From: Sue Howell <Sue.Howell@arun.gov.uk>
Sent: 20 December 2019 13:26
To: Planning.Responses <Planning.Responses@arun.gov.uk>
Cc: Michael Eastham <Michael.Eastham@arun.gov.uk>
Subject: FW: Planning Consultation on: LU/305/19/RES

Further to submission of revised Landscape drawings A 088461 LA300-303 (0) and specifically drawing LA303 Trev 0 LEAP Design, I can confirm that the detail has taken on board our comments and requirement for the inclusion of further play experience as this is to be a double LEAP.

Description of Works: Application for Reserved Matters following outline permission
LU/47/11 for 46 dwellings - This application may affect the setting of
a Listed Building - This is a resubmission of LU/379/18/RES

A088461 LA300-303[L].dwg

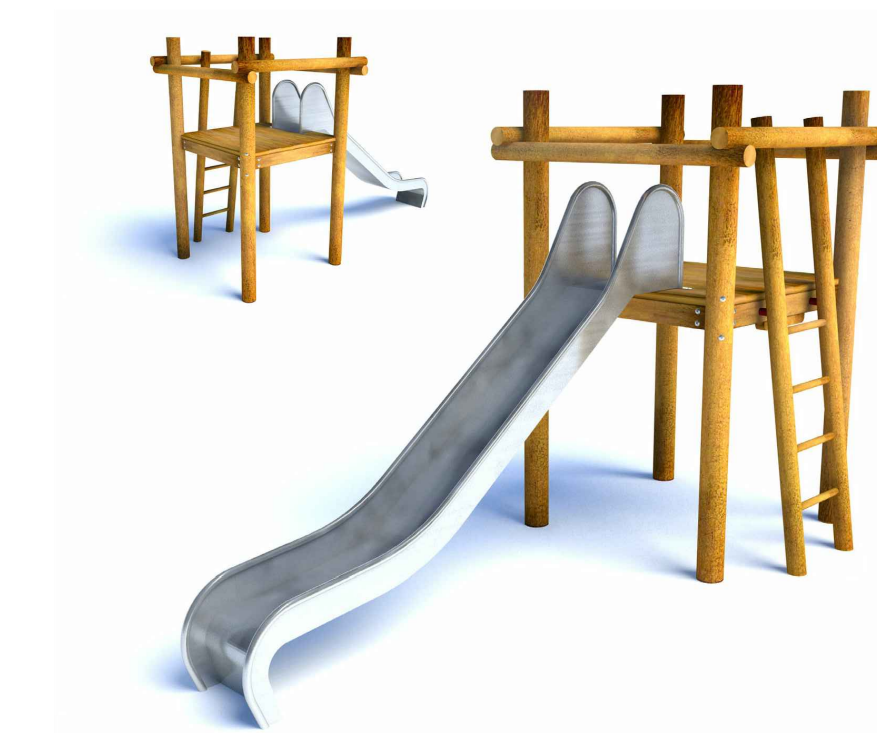
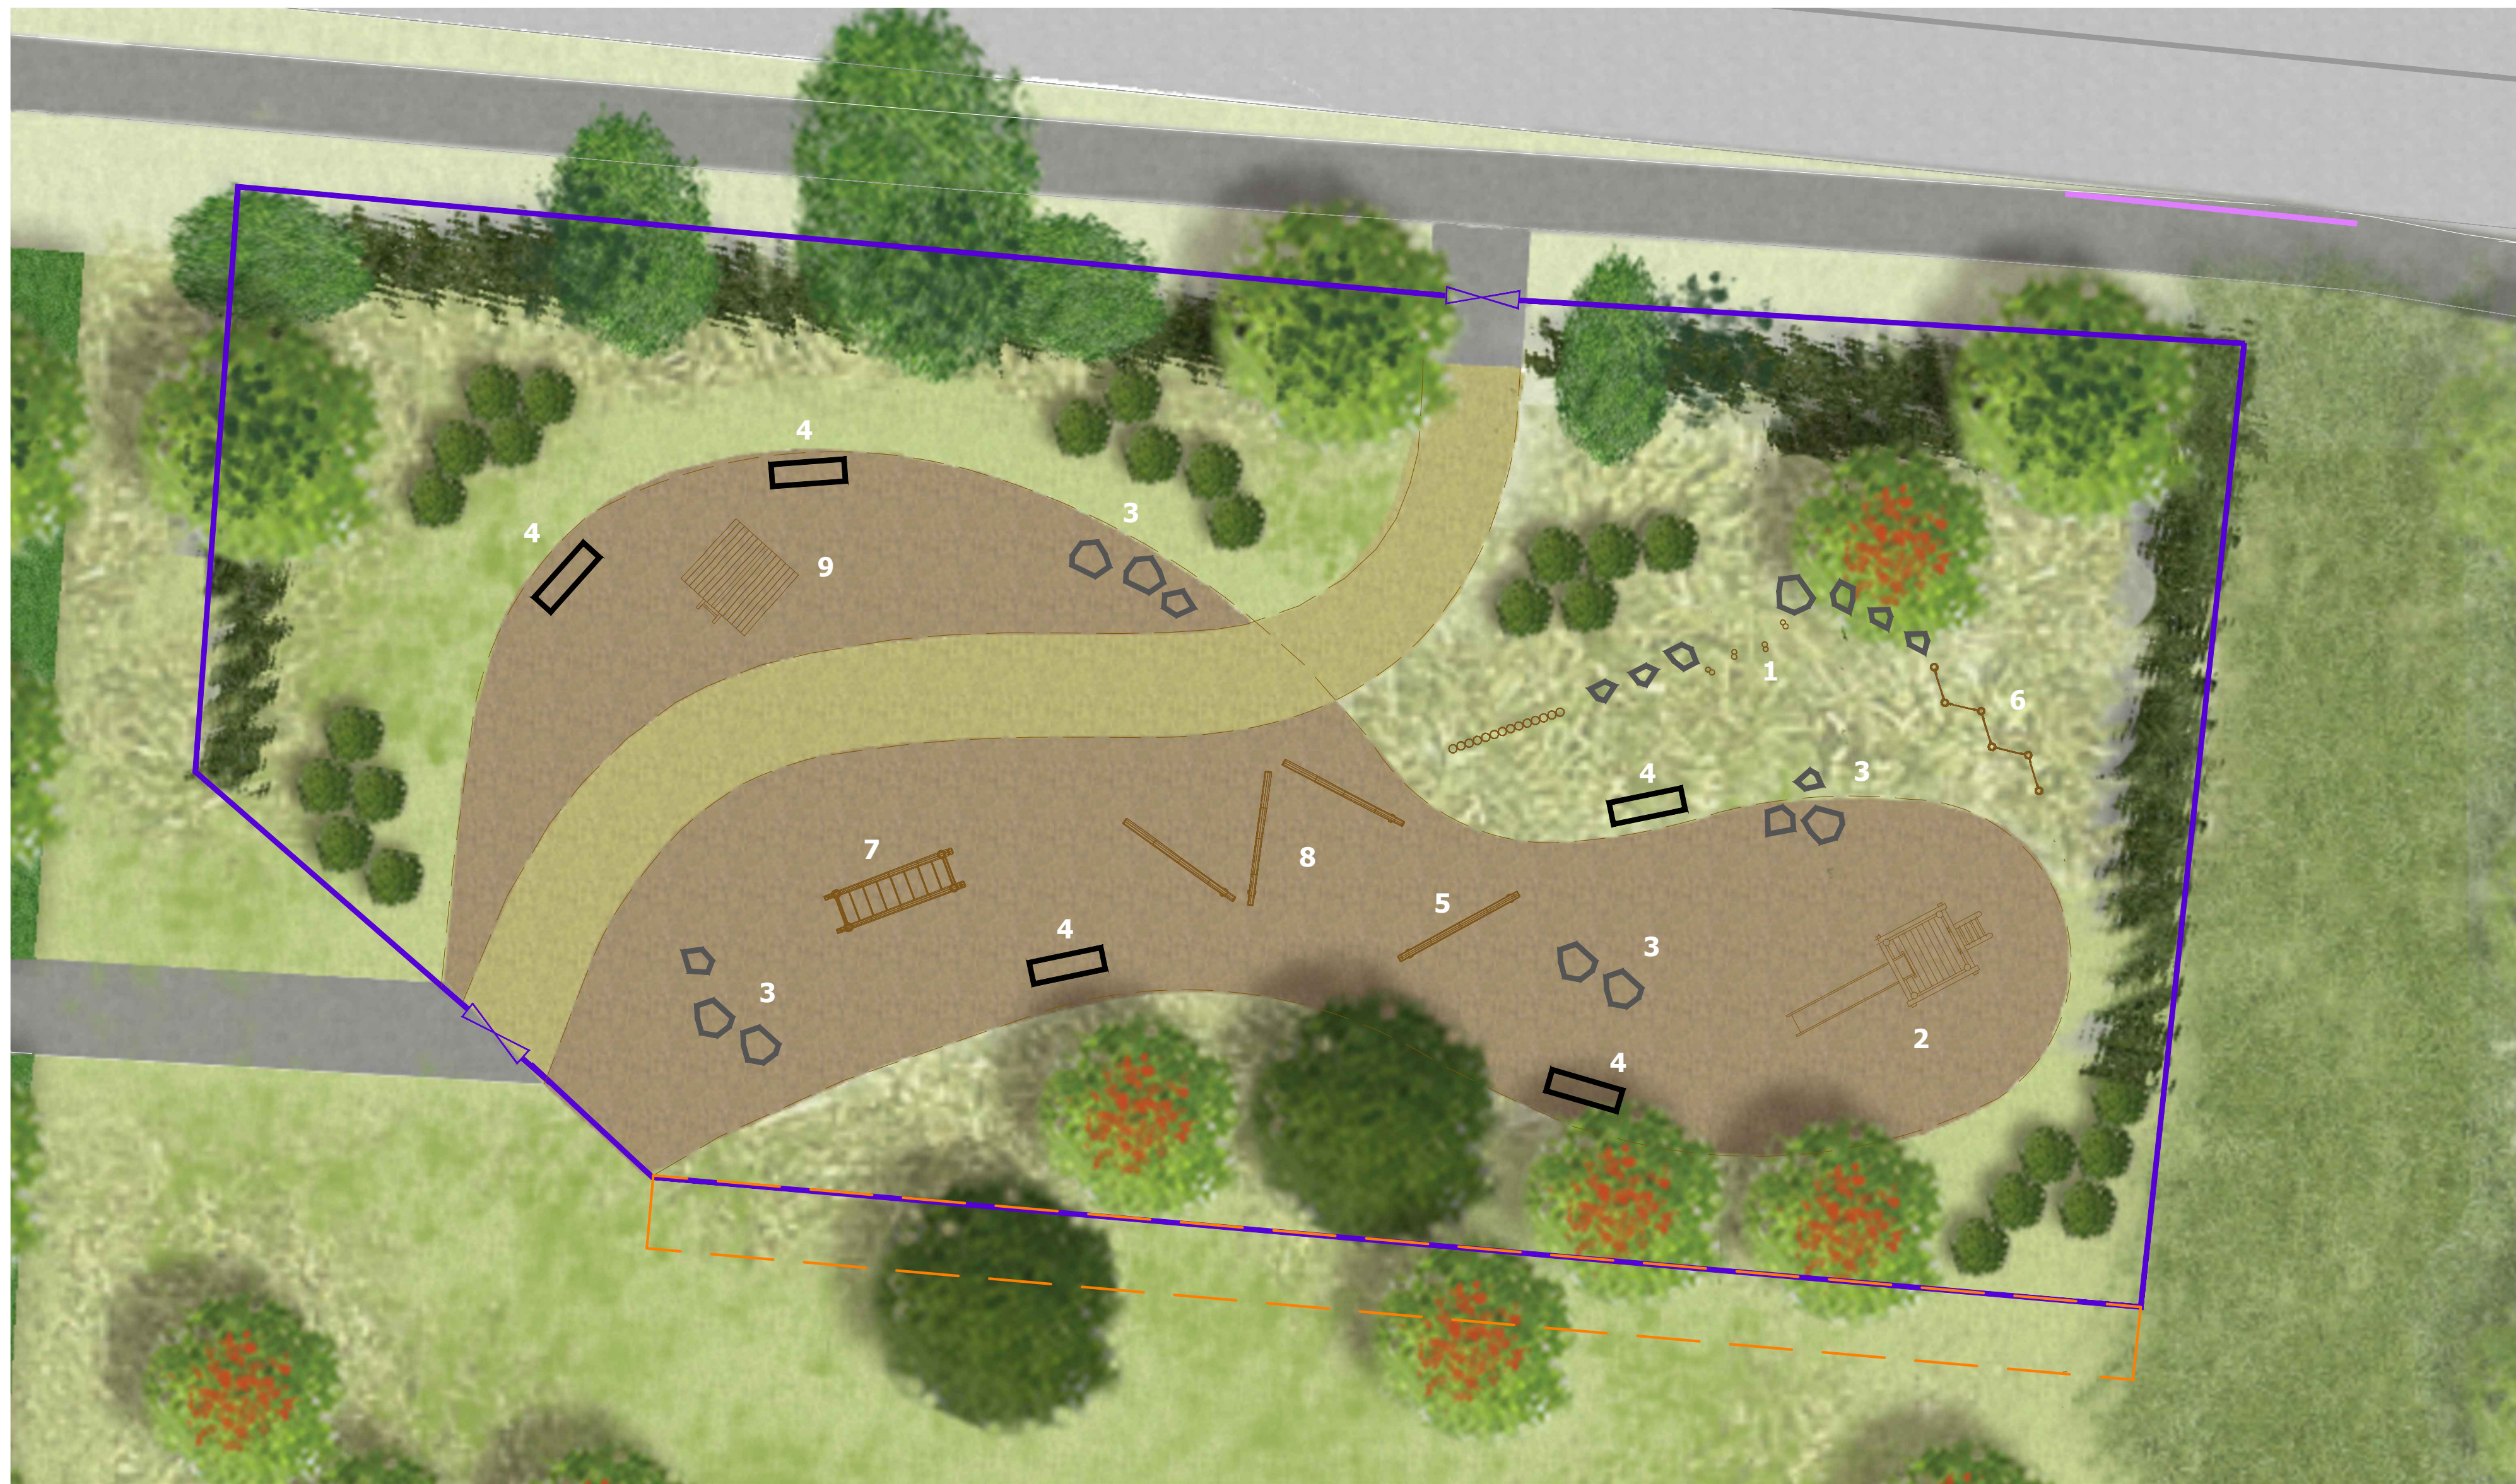
LEAP design Dwg LA 303 REV L LA 300-303 (L) has proposed a spacious and well located play area, however the play offer contained would appear to be too limited in play experiences proposed. The play has focused largely on climb and balance and whilst the choice of material – wooden is good and the items themselves ok, due to the limited experience being offered I would recommend that swing, spin, twist possibly rock are incorporated into this LEAP design. My understanding is, that as this was to be a double LEAP- due to under provision on another phase then the incorporation/substitution of further play experience here is imperative. I would like to see this additional play in the same material palate which is good and suitable for location. I would add a note of caution re the safety surfacing being bark mulch as this has the tendency to provide maintenance issues going forward, but defer to your play advisors for consideration. Pathway, gates and seat, good to see incorporated, the addition of a litter bin would also be useful to see. One of the access gates would need to be accessible for maintenance operations.

We would have to advise that **I would NOT recommend the approval** of reserved matters on this application LU/305/19/RES **relating to LEAP** until the points I have raised above have been considered and addressed.

A088461 LA300-303[O].dwg

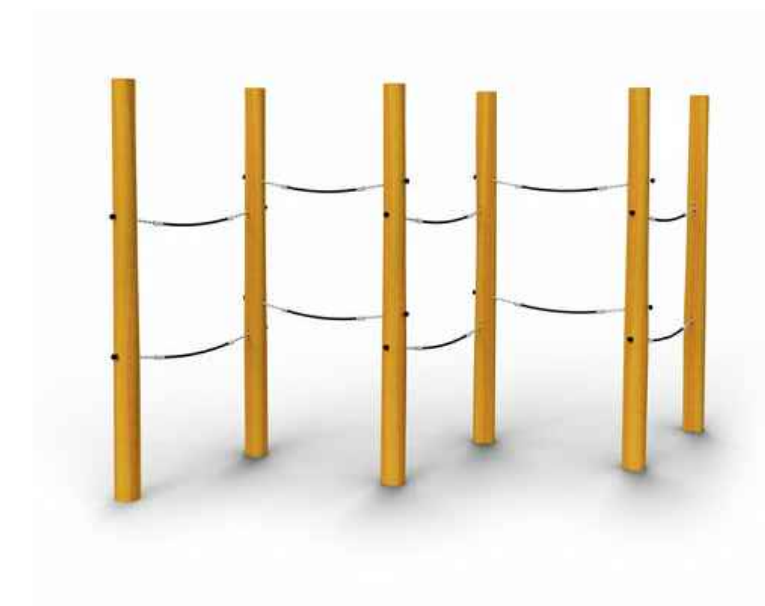
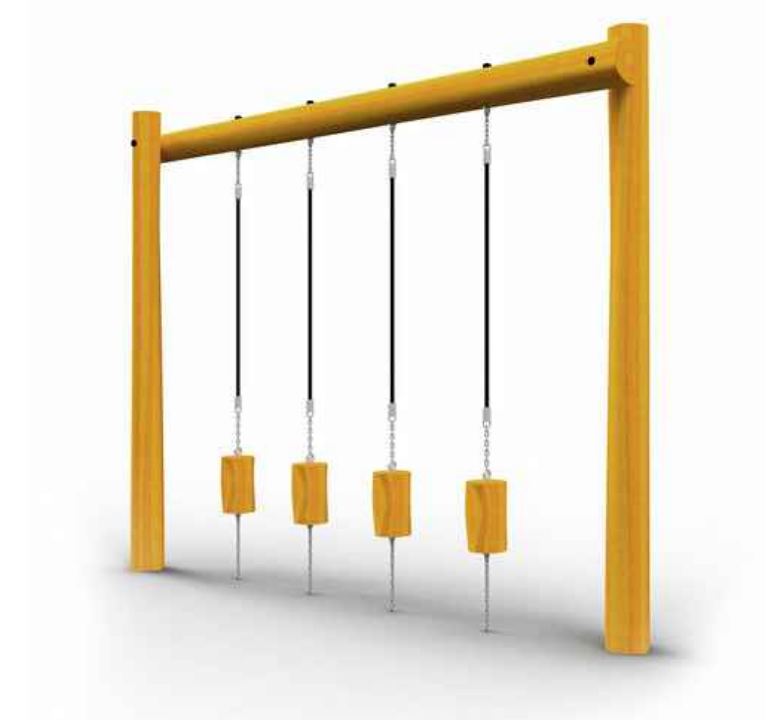
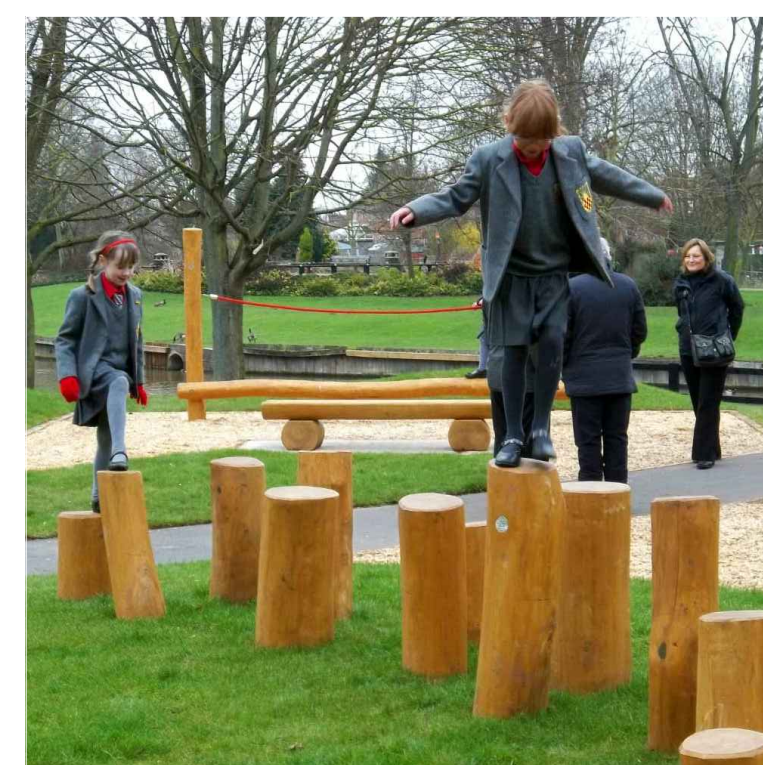
The inclusion now of rotating, swinging and see saw experiences, litter bin, double maintenance gate and the substitution now to a bonded rubber mulch surfacing is all great to see.

A point of note would be the legend does not match that depicted for play item No 3 which is a climbing unit with slide not a further set of swings and a note of caution would be the siting of the jumping blocks next to the boulders. As it would be a requirement that the play area be subject to a RoSPA or similar body inspection, I will assume that this will be assessed.
